Response to Submissions

For:
Proposed IKEA Multi-Function Logistics Unit and
associated Estate Civil and Infrastructure Works
SSD_6954

At:
Lot, 1, 3 and 4 in DP1208554, Lot 128, 132 in
DP1194052 and Lot 102 in DP1188147
Sydney Business Park – Marsden Park

November 2015

FDC BUILDING IKEA MFLU MARSDEN PARK SITE TURNING PATHS - SHEET 1			
Datum AHD	Date 13/11/15	Scale AS SHOWN	Size A1
Drawing Number 80215051-SK212			Revision 1

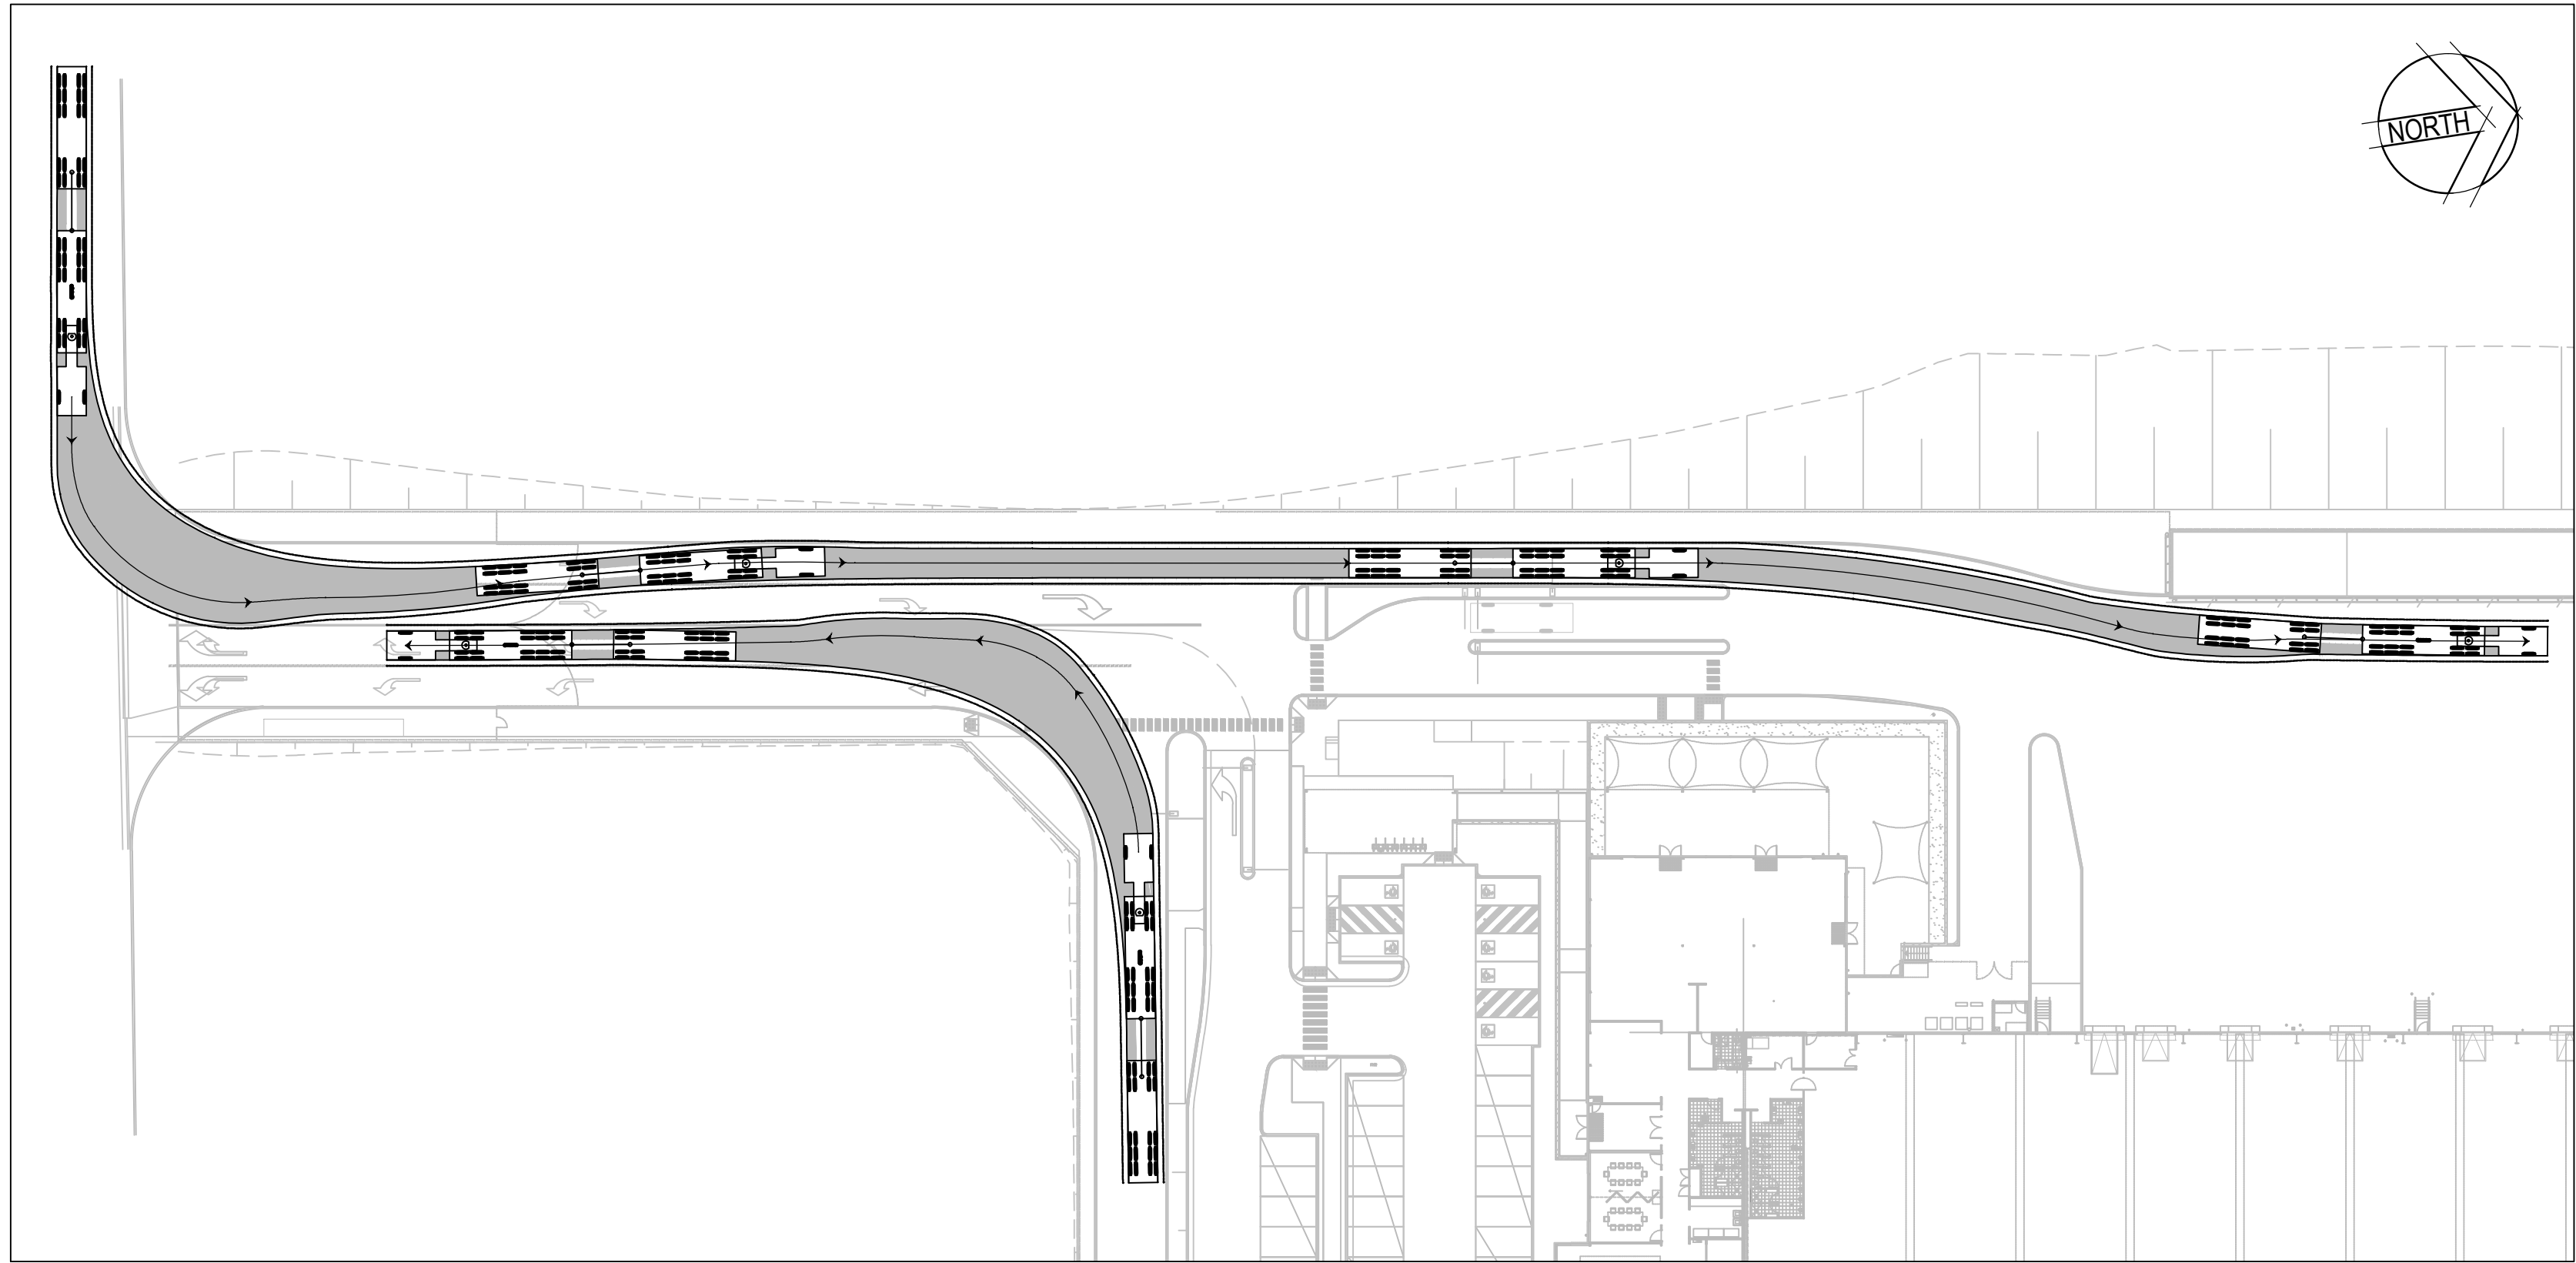
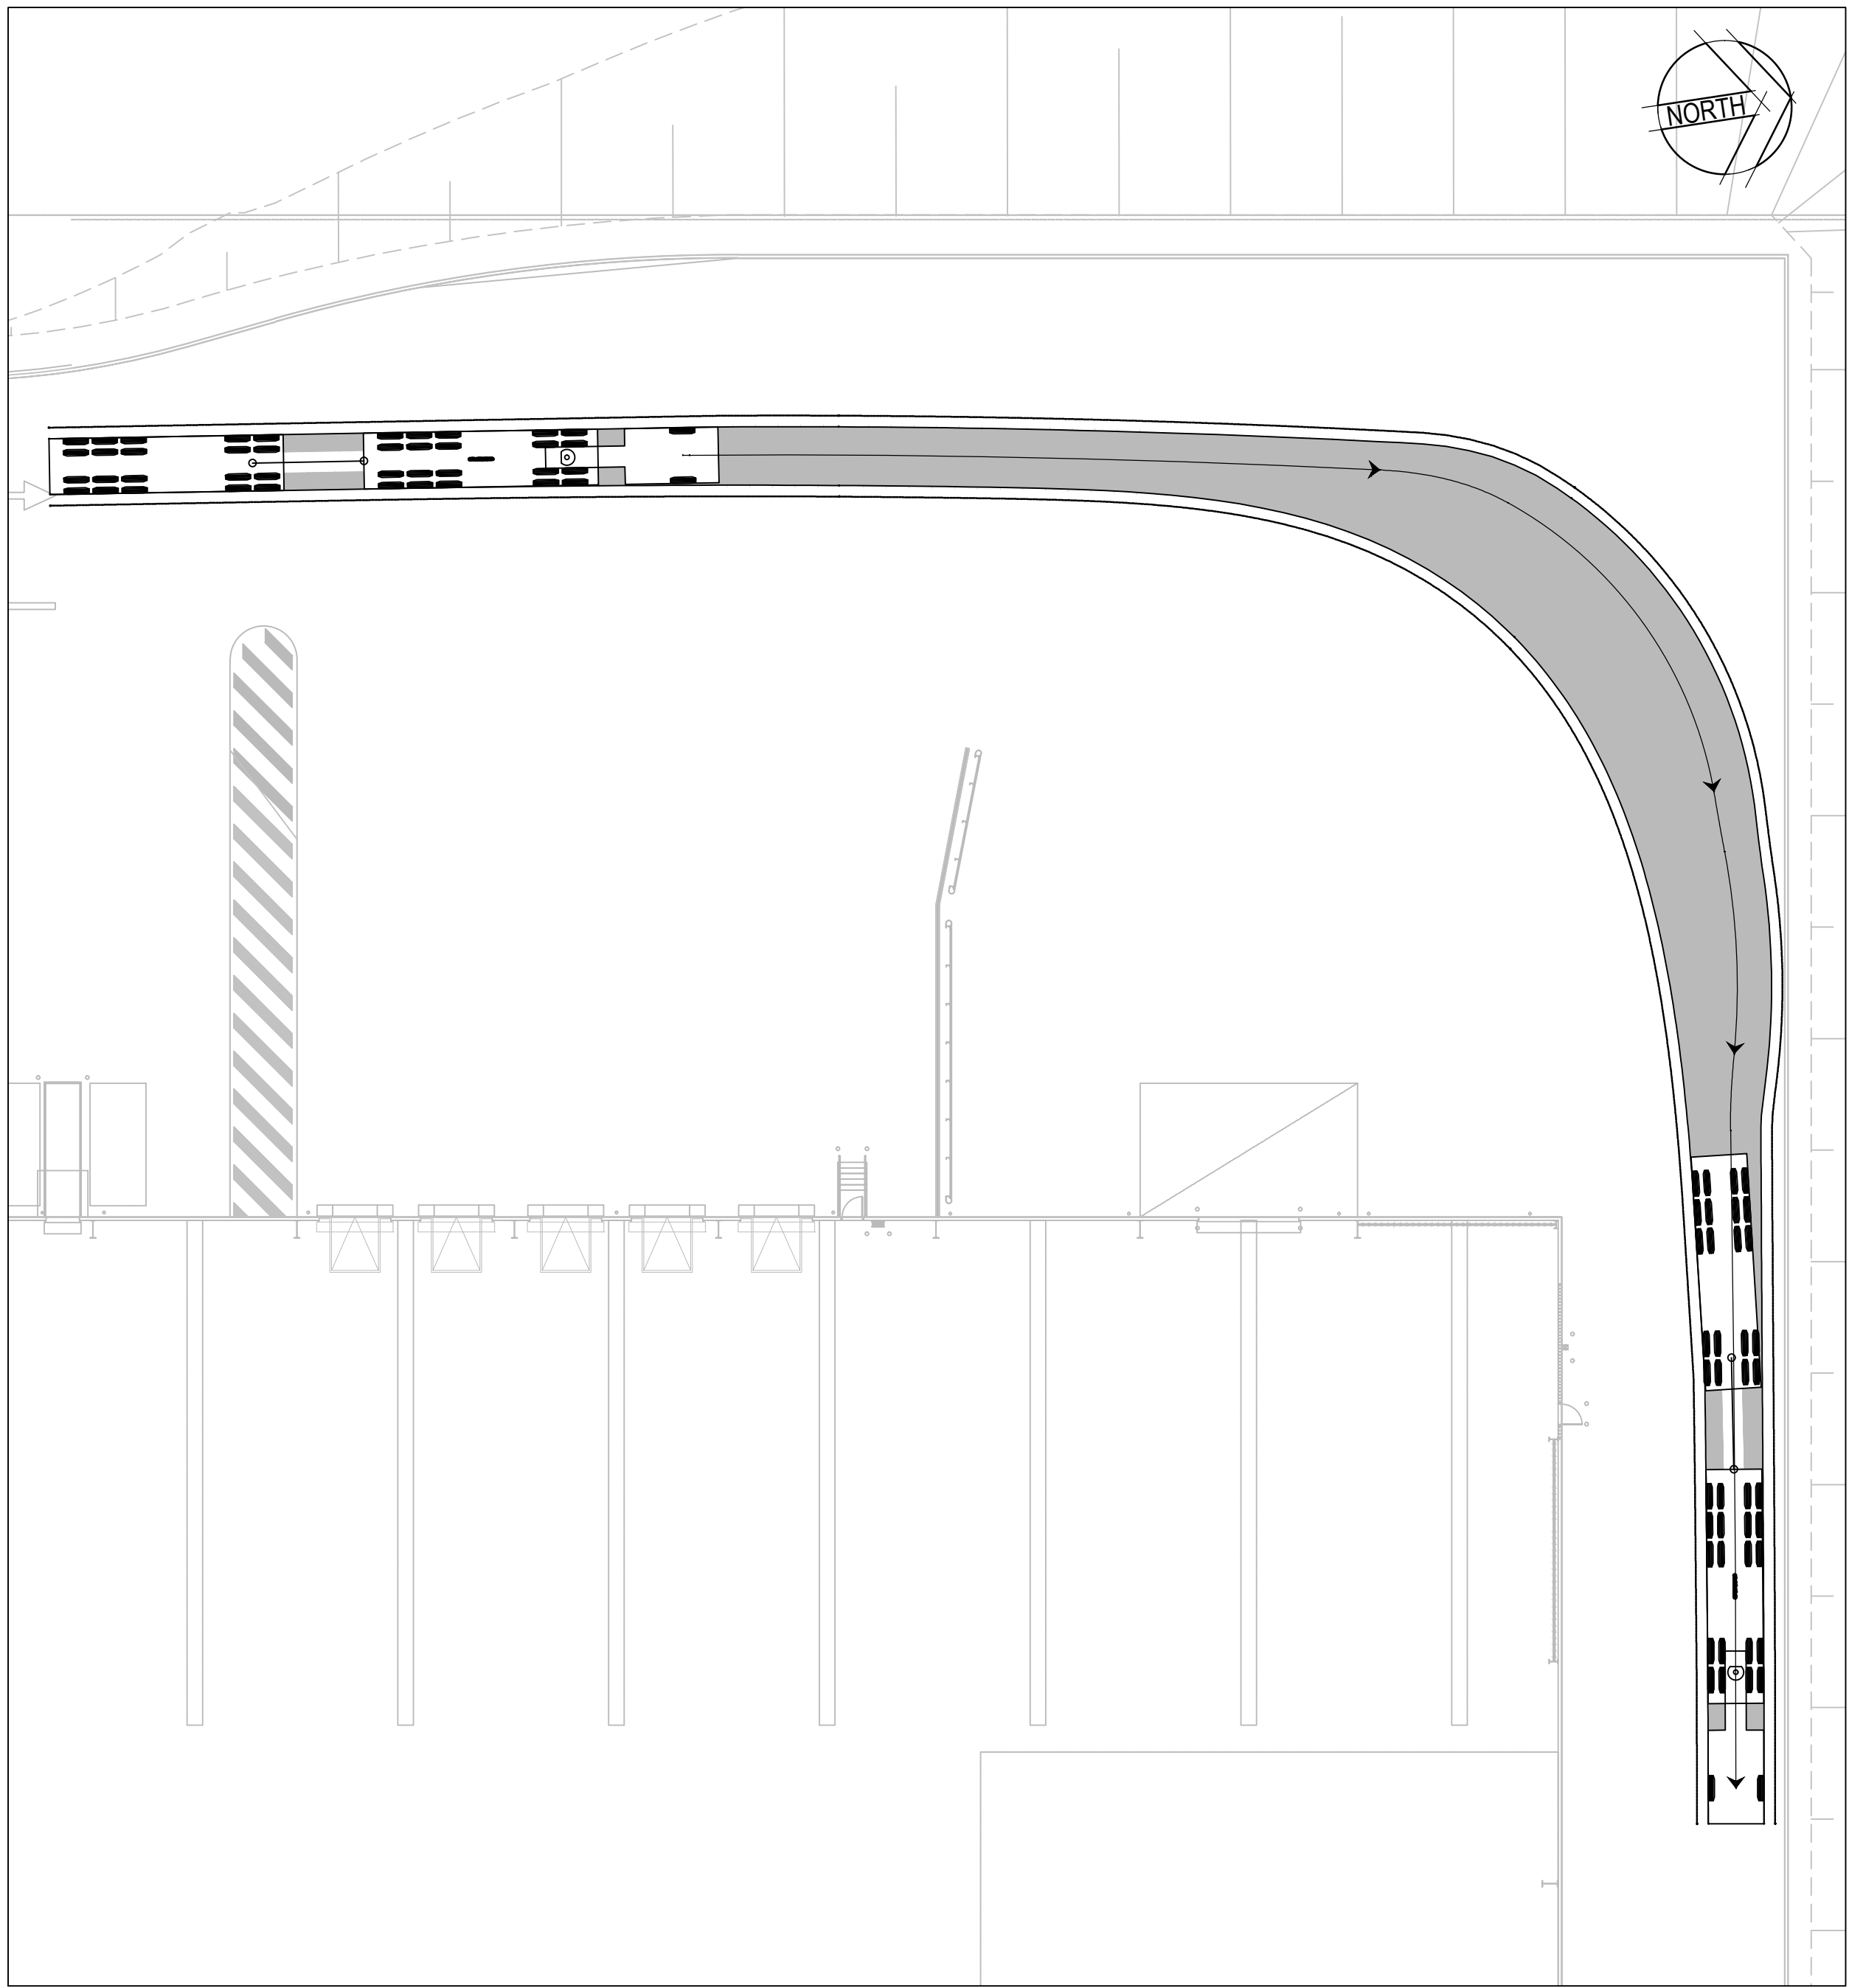
Issues	Response
Design Vehicle The design vehicle (25m B-Double) that has been chosen to test the turning path (internally and at the access point) of the largest heavy vehicle is considered appropriate given the existing heavy vehicle fleet in operation. However, it would be prudent to adopt turning path of a vehicle PBS Level 2B (i.e. up to 30m in length) to test the largest vehicle combination likely to access the development for the foreseeable future. It is however noted that the size of the design	Cardno has assessed the proposed PBS Level 2B design vehicle (i.e., up to 30 metres in length) and can confirm that with some minor on site modifications, the site could accommodate a 30 metre long vehicle. Copies of the track runs are attached for reference as part of the civil design package in Appendix 2. Such vehicles are not required by IKEA as part of their operation as indicated within the EIS. However, if this was to change,

vehicle may be restricted by the geometry of the local road network. Therefore, swept path analyses should be undertaken along the proposed heavy vehicle access route from the subject site to the major freight route (i.e. Richmond Road) to determine the largest vehicle that would be able to access the site. Appropriate conditions should be included in the consent condition restricting the size of heavy vehicle servicing the site to the design vehicle.

The estate road network has either been designed to accommodate such vehicles or not. If not, IKEA will not change their fleet that services the site. No further assessment is considered necessary.
